**DEVIATION REVIEW
 AND DECISION FORM**

Subdivision or Project Name:
 Gleneagle Golf Course Residential Infill Dev Fil No. 2

Section of ECM from Which Deviation is Sought: 2.3.8.A Roadway Terminations, Cul-de-Sacs.

Proposed Nature and Extent of Deviation: Allow a cul-de-sac bulb with a reduced radius of 39 feet at the end of Stone Eagle Place.

Figure 1

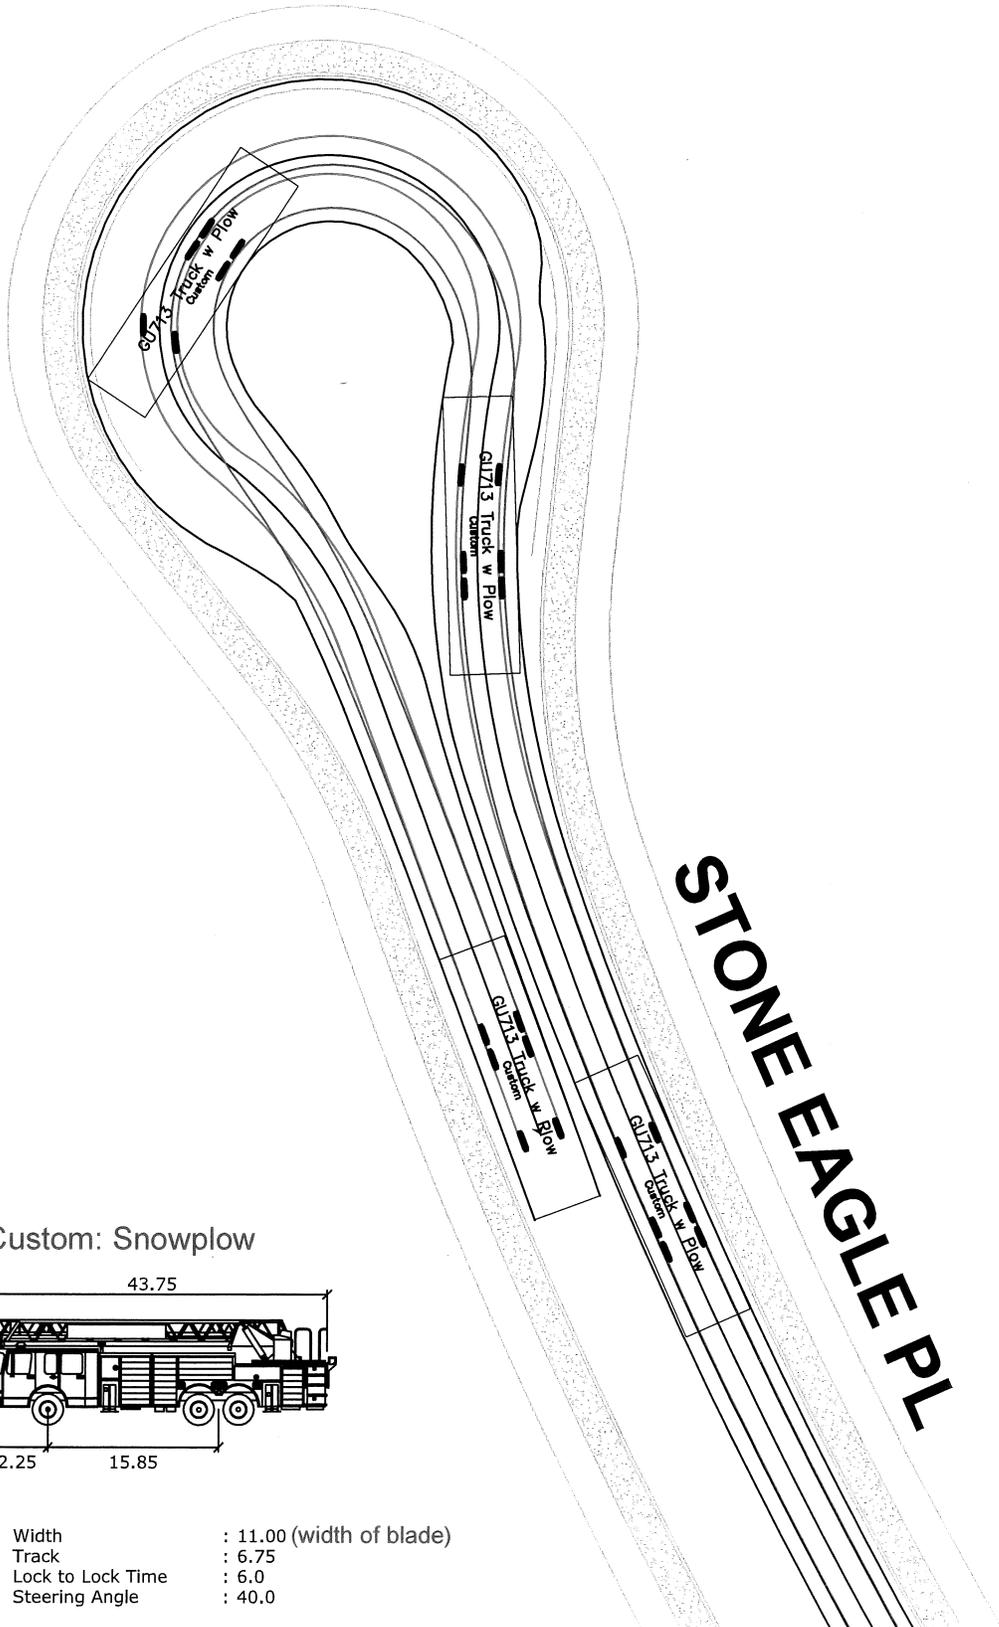
[Provide a letter from Westcott Fire District that is specific to the reduced size of the cul-de-sac radius.](#)

LSC Response: The deviation has been updated to include a letter from Westcott Fire District that is specific to the cul-de-sac radius.
